## FINDINGS OF FACT AND CONCLUSIONS OF LAW

### Tuttle Zoning Setback Variance VA-20-00011

This matter having come before the Kittitas County Community Development Services for the Tuttle Zoning Setback Variance (VA-20-00011) submitted by Brooks Tuttle to reduce a 25 foot front yard setbacks within the Residential Zone to 8 feet along the East property line. This variance is in order to facilitate construction of a RV Storage Shop with a second story access point.

Pine Lock Sun III

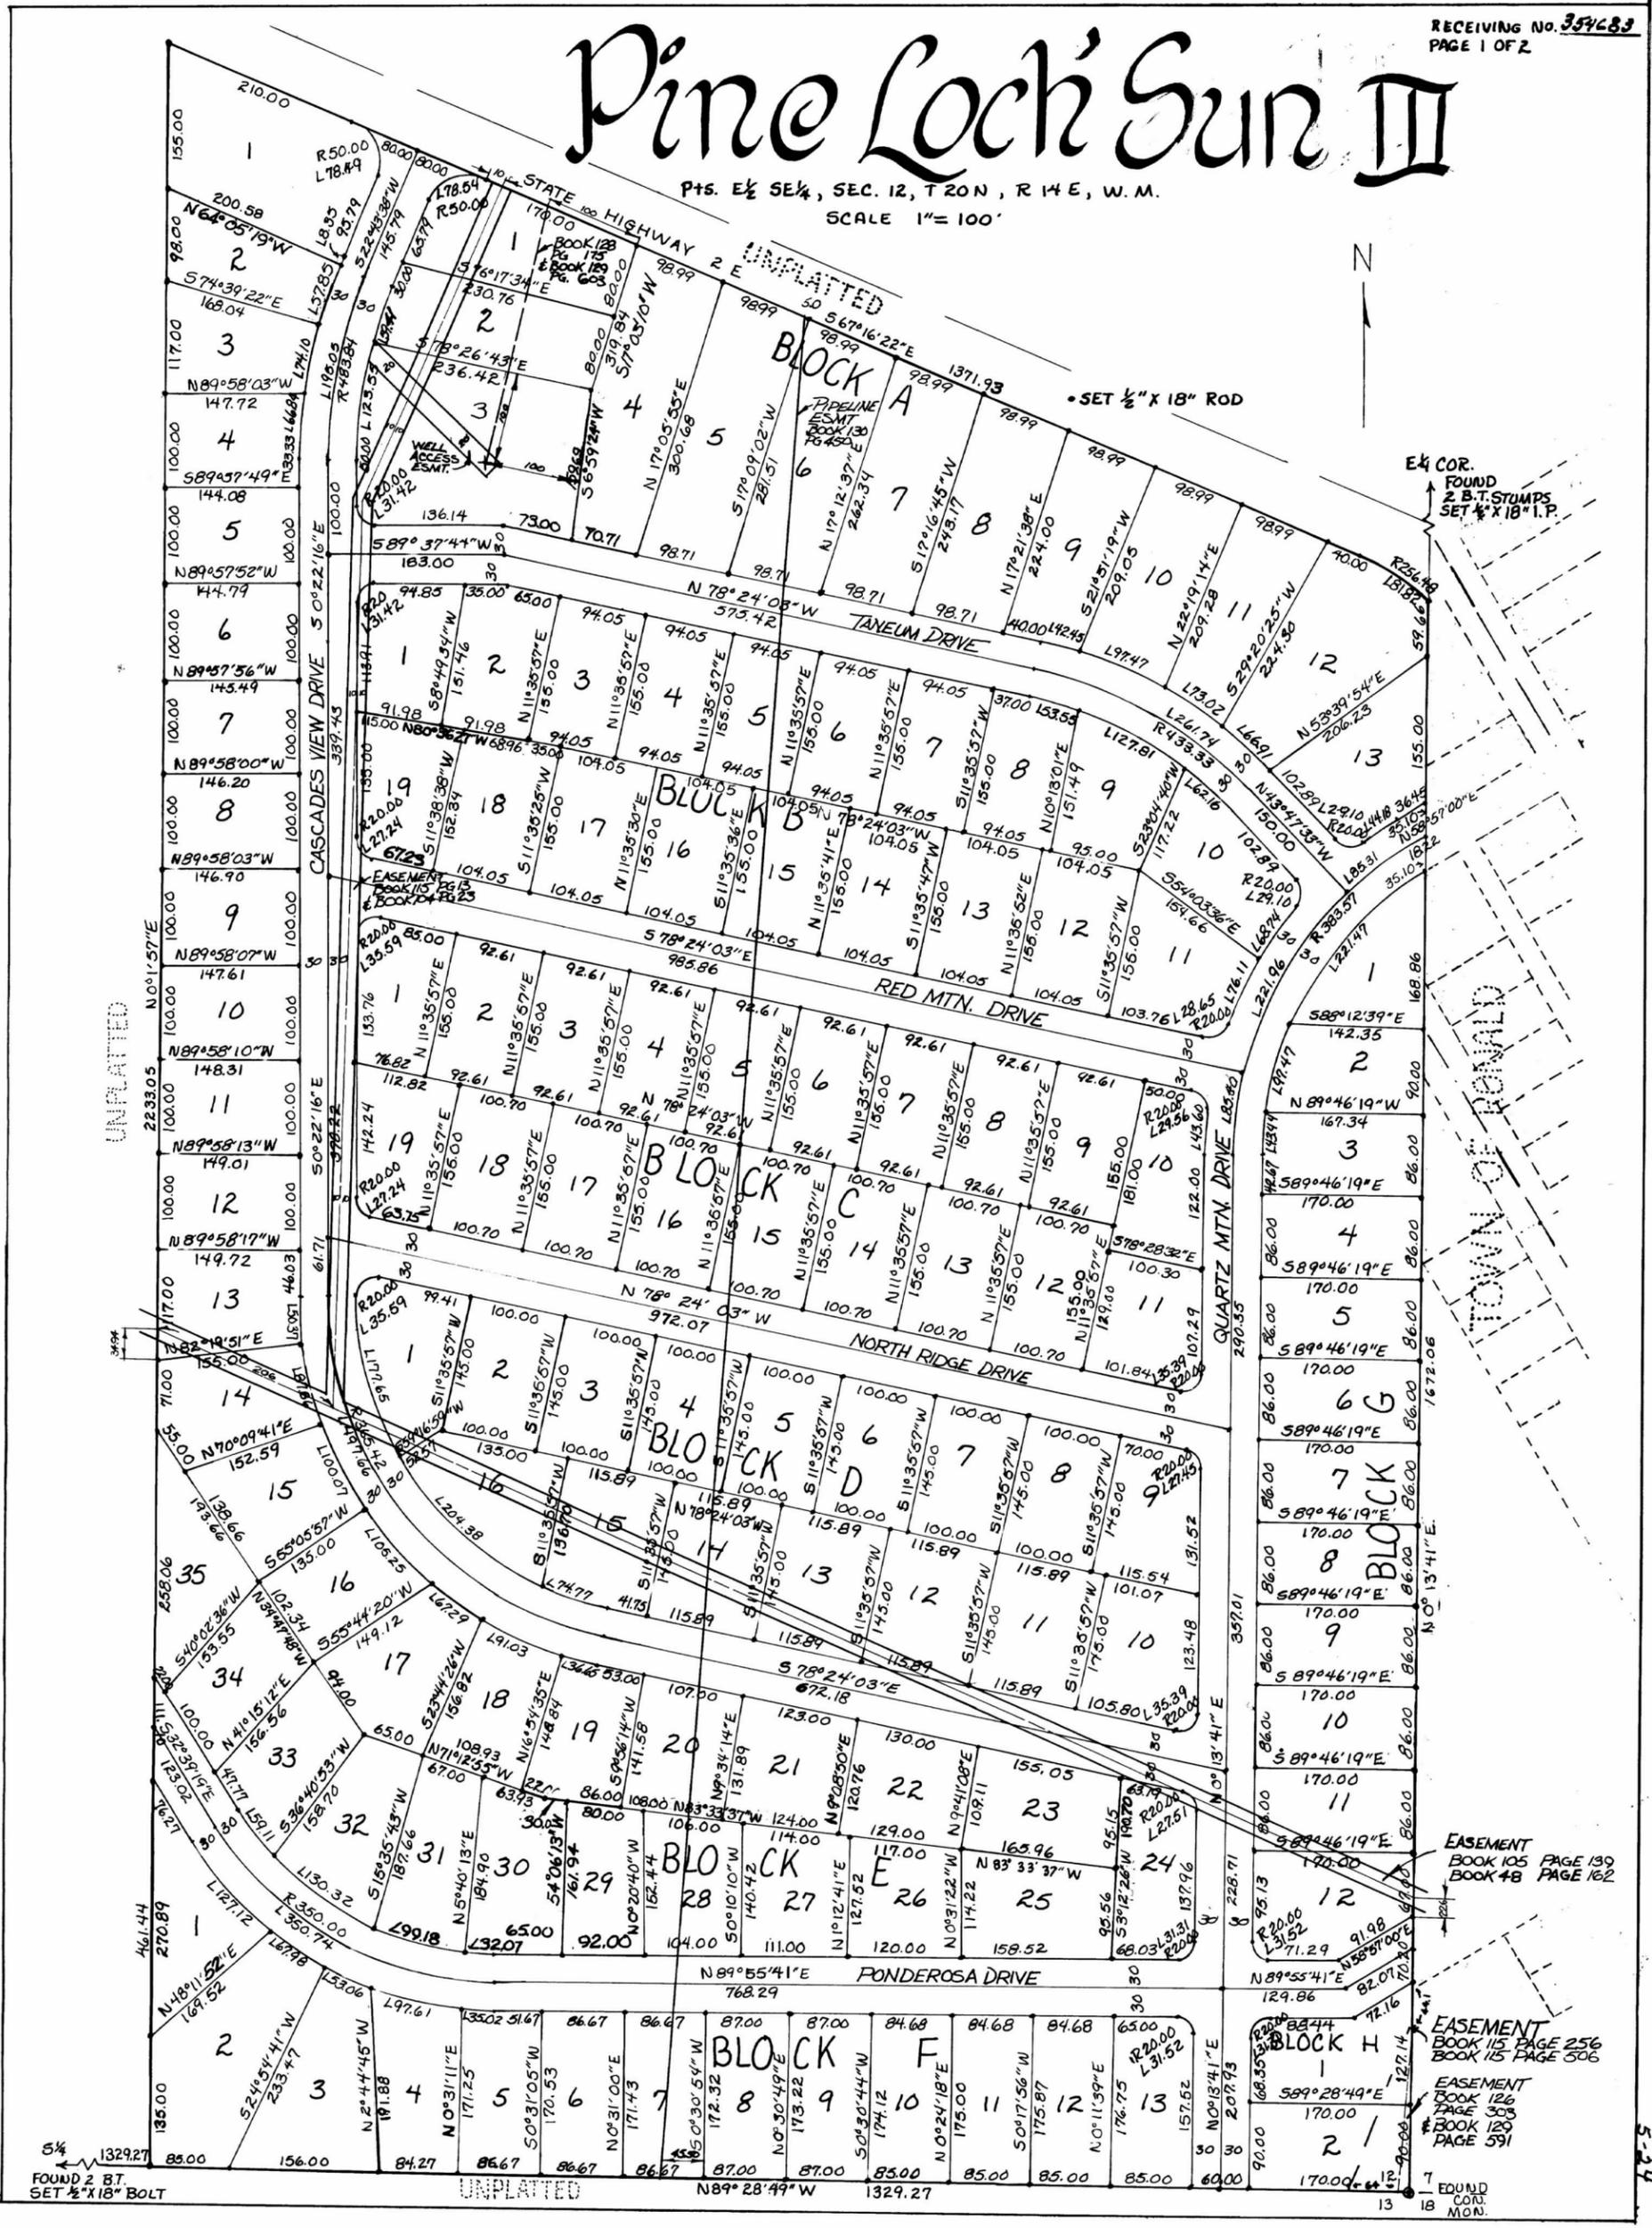
3. KCPW: Kittitas County Public Works submitted comments noting an easement that will have to be observed along the northern property boundary. KCPW also noted some issues with the site plan that seem to contradict the related Pine Loch' Sun development survey. KCPW also noted the grade and fill thresholds for a Grade and Fill permit.

CDS has conditioned this determination to ensure that the applicant observe all legal lot line and easement locations and base this variance reduction on the official lot lines. Additionally the threshold for a Grade and Fill permit have been noted in the conditions.

2. The applicant shall not encroach on any easement or right-of-way.
3. Any grading over 100 cubic yards of material will require a grading permit from Kittitas County Public Works.

4. The applicant shall ensure all structural setback distances are measured accurately from legal property lines.
5. This front lot line setback variance shall expire after one year of the decision date if no substantial construction has taken place.
